DEVELOPMENT REVIEW BOARD
SUPPLEMENTAL SUBMITTAL

PROJECT NO. PR 2018-002559
Application No. SD 2019-00055

DRB Project Number: 2019-002559
University Heights Addition

SUBJECT: Vacation, Plat

PLAT OF
LOTS 1-A-1 & 1-A-2, BLOCK 10
UNIVERSITY HEIGHTS ADDITION

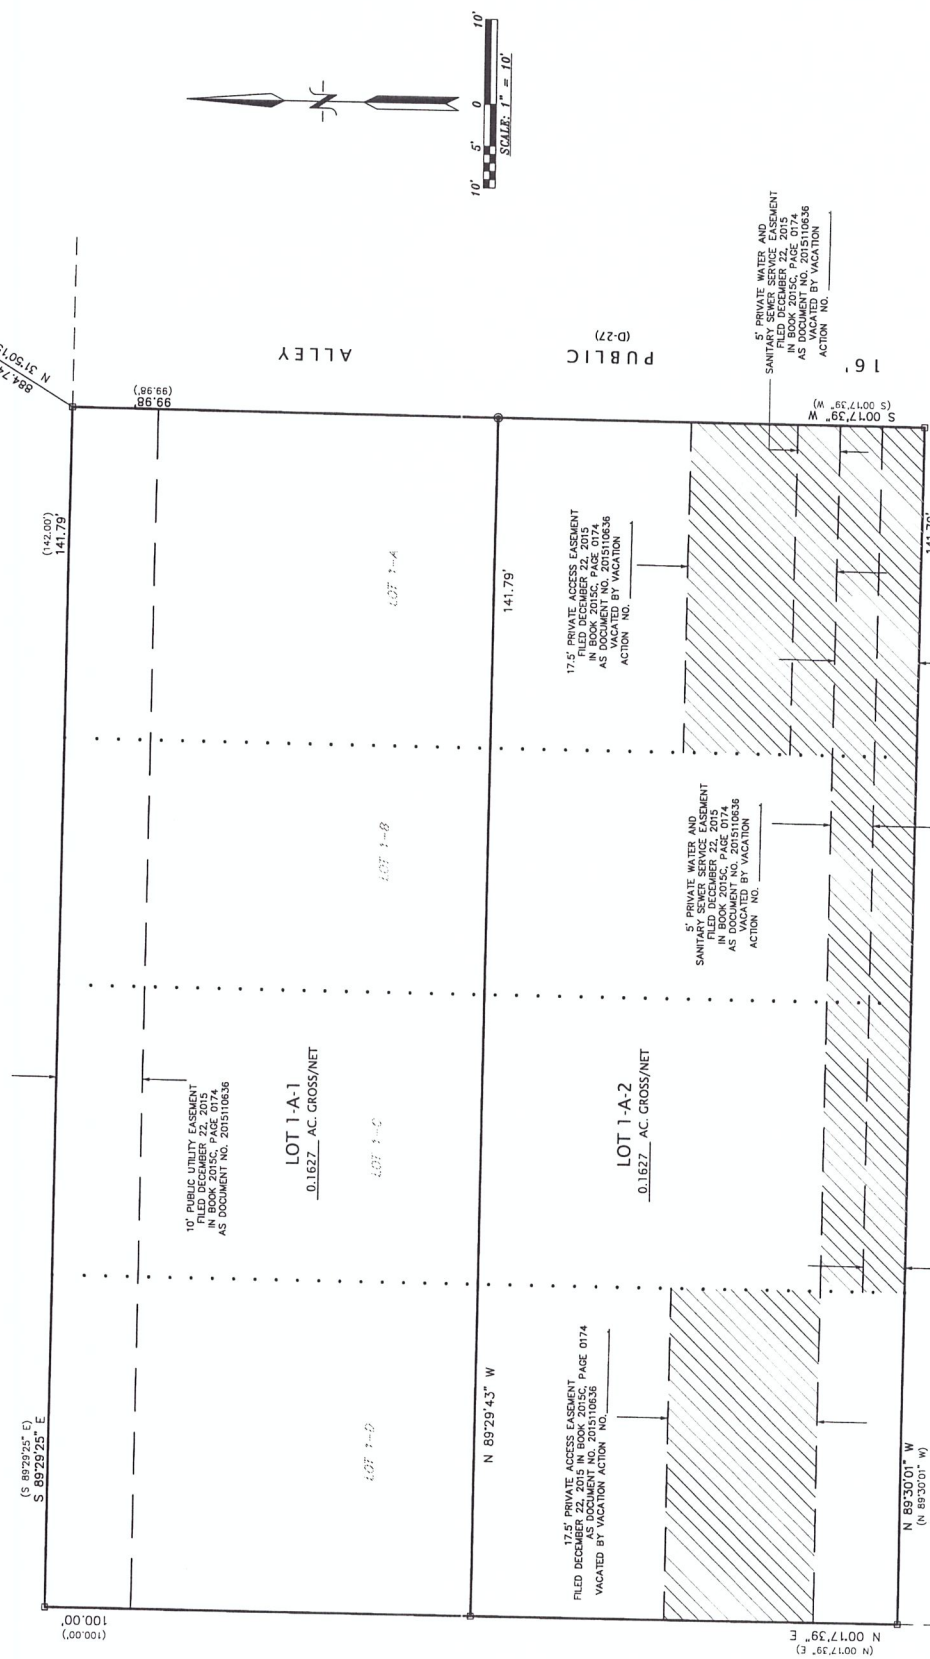
1. Transportation Department has no objection to the vacation of the easements.
2. Right of Way dedication is required to add a curve to the northwest and northeast corners of the property abutting Silver Avenue. (Sight distance is of special concern at Silver/Cornell based on pavement markings for yielding and crosswalks.) Refer to DPM Table 23.3.3 for requirements.
3. Infrastructure list is required to widen alley, and the current standard for alleyway right-of-way is 20 feet. Right-of-way dedication is required.
4. If future development is not going to be submitted to DRB, a TCL (Traffic Circulation Layout) will be required before building permit.

1. **Transportation Department has no objection to the vacation of easements.**
2. Right of Way dedication is required to add a curve to the northwest and northeast corners of the property abutting Silver Avenue. (Sight distance is of special concern at Silver/Cornell based on pavement markings for yielding and crosswalks.) Refer to DPM Table 23.3.3 for requirements
RESPONSE: Updated plat reflects curves added to the northwest and northeast corners as per DPM requirements.
3. Infrastructure list is required to widen alley, and the current standard for alley way right-of-way is 20 feet. Right-of-way dedication is required.
RESPONSE: Request for waiver provided.
4. If future development is not going to be submitted to DRB, a TCL (Traffic Circulation Layout) will be required before building permit.
